The British Horse Society

Planning Inspectorate

21 Nov. 24

Oaklands Solar Farm proposal

Trailer of HGV enters opposing lane on turn due to the angle of the bend.

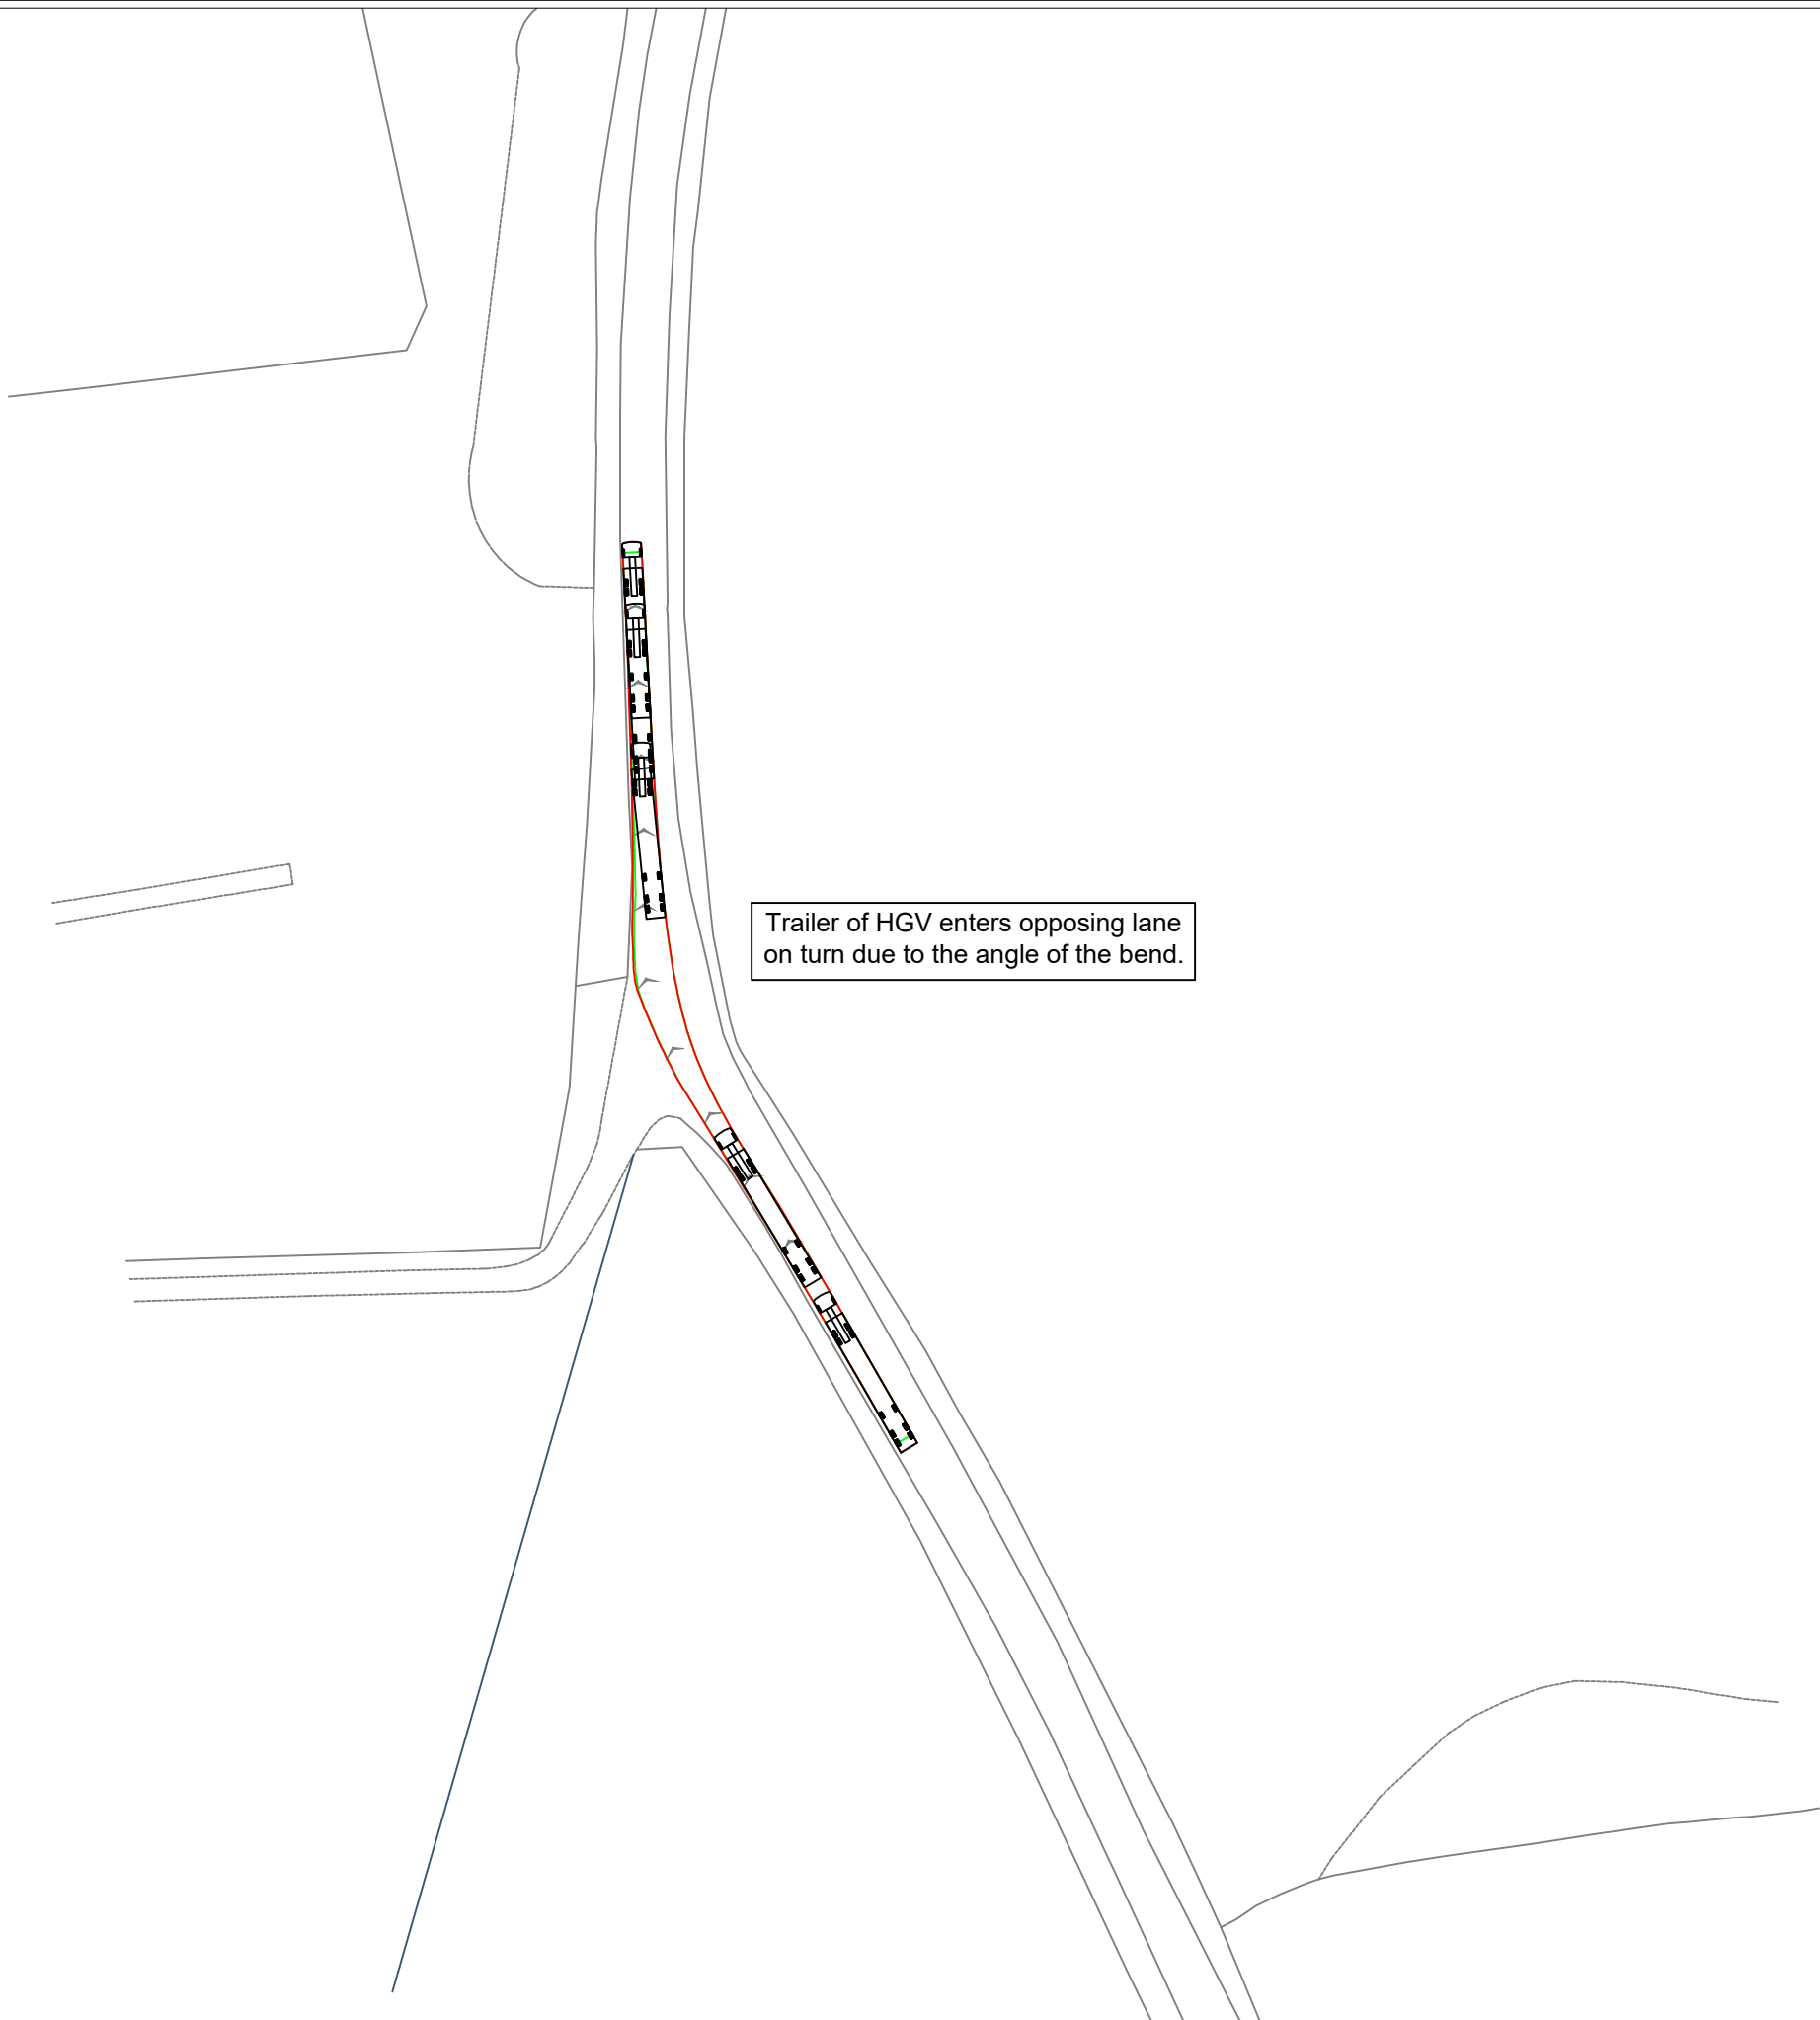
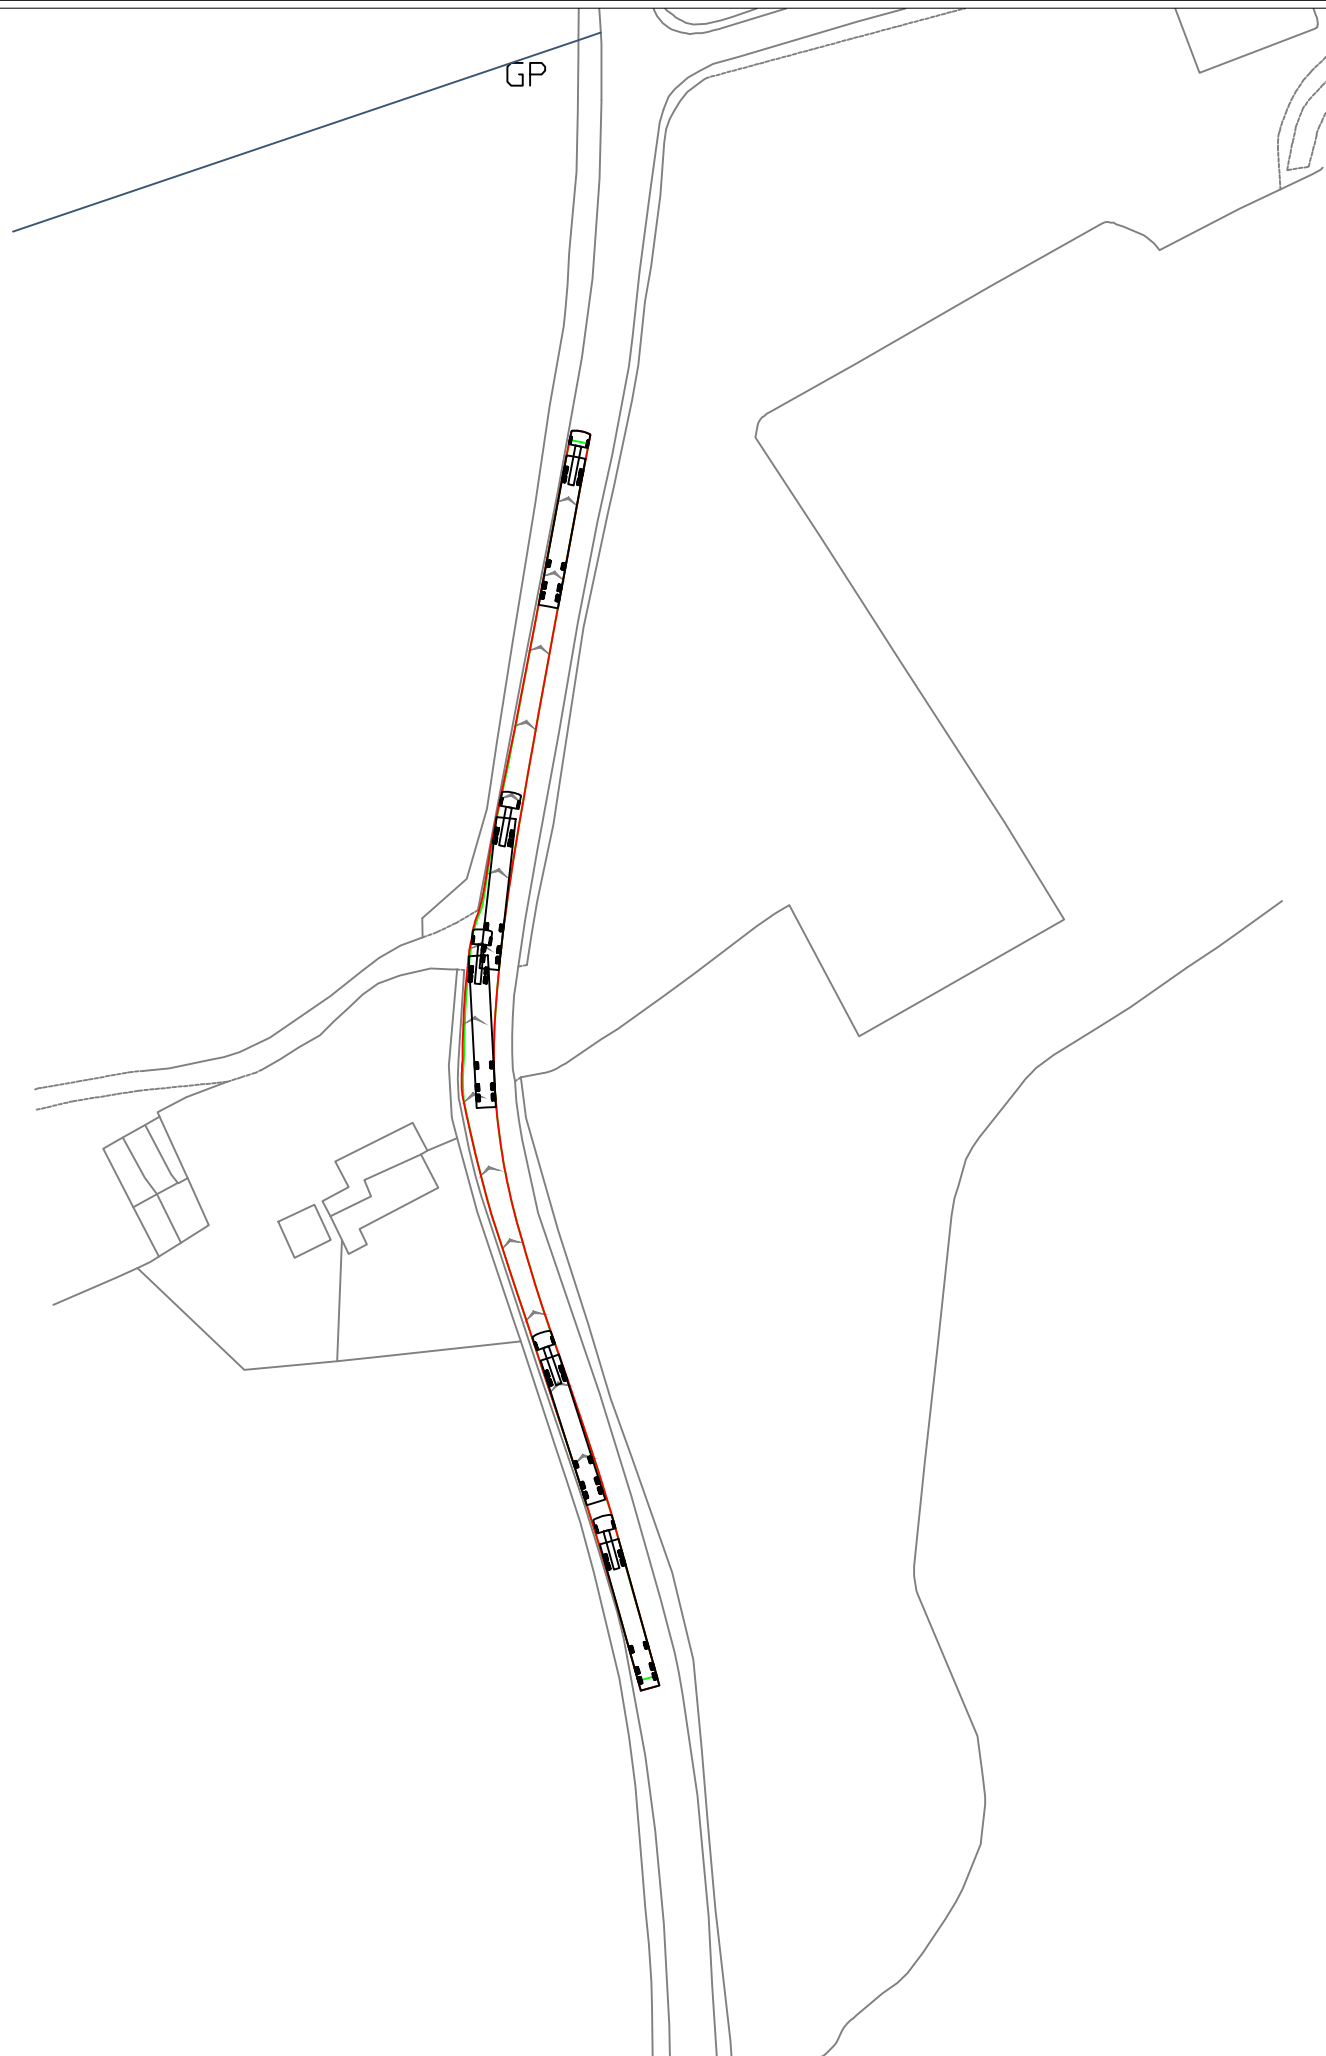
- An abnormal load is mentioned. Local riders are concerned that the abnormal load route would pass both Grangewood livery and Sealbrook livery yards. How will this be managed for safety?
